From: Richard Guyatt <richard.guyatt@wbd-uk.com>
Sent: 23 October 2020 18:11
To: Bartkowiak, Bart <Bart.Bartkowiak@planninginspectorate.gov.uk>
Cc: Metrowest1 <Metrowest1@planninginspectorate.gov.uk>; James Willcock (<James.Willcock@n-somerset.gov.uk> <James.Willcock@n-somerset.gov.uk>); Tom Ewings <Tom.Ewings@wbd-uk.com>; Frances Everett <frances.everett@wbd-uk.com>
Subject: MetroWest Phase 1 - Open Floor Hearing - Mrs Freestone [WBDUK-AC.FID ██████████]

The Portishead Branch Line (MetroWest Phase 1) Order Open Floor Hearing - 19 October 2020

Works Plan [AS-013] – this shows part of the land forming plot 05/151. This incorrectly included within the boundary for Work No. 17, the temporary construction compound on Lodway Farm.

674946.BQ.42.01-385 E

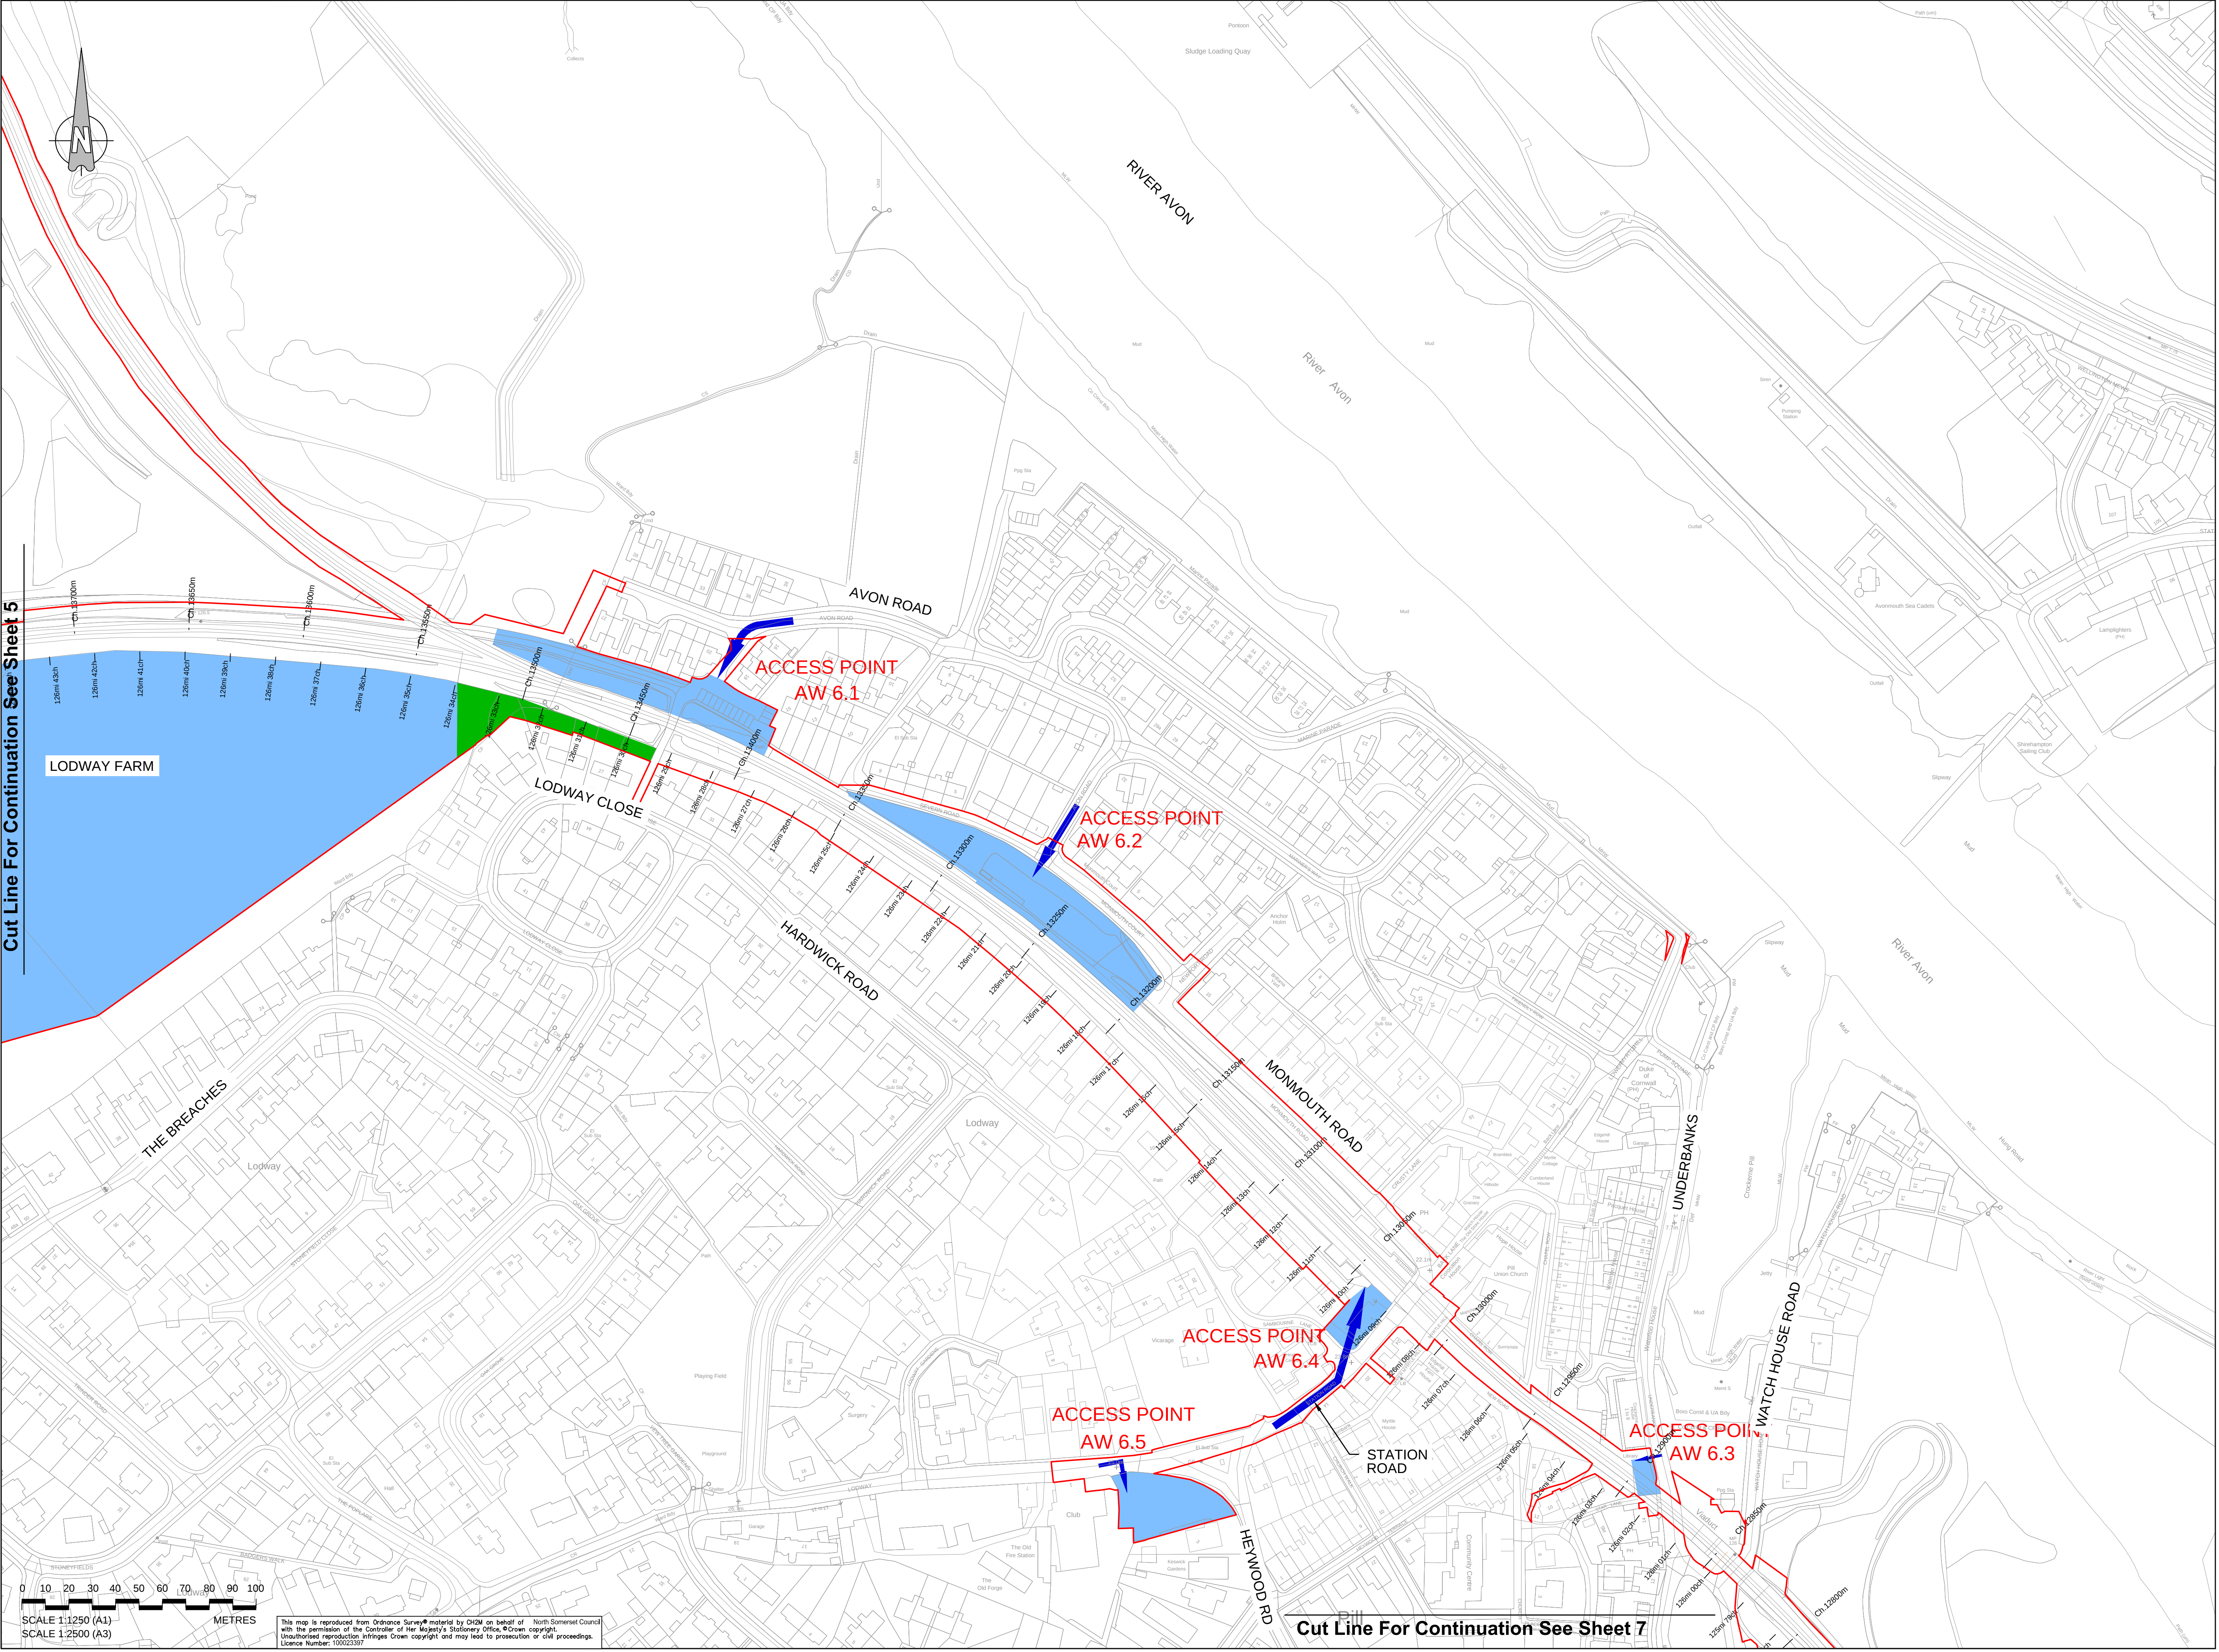
Compound, Haul Road and Access to Works Plan [APP-024] – part of plot 05/151 is incorrectly shaded to suggest it is part of the Lodway Farm construction compound.

In an attempt to assist I've prepared an annotated version of the Works Plan to show you how the Lodway Compound will be shown in the amended plans. Those amended plans should be available next week. My rough sketch of the proposed change to the Works plan Sheet 5 is below:
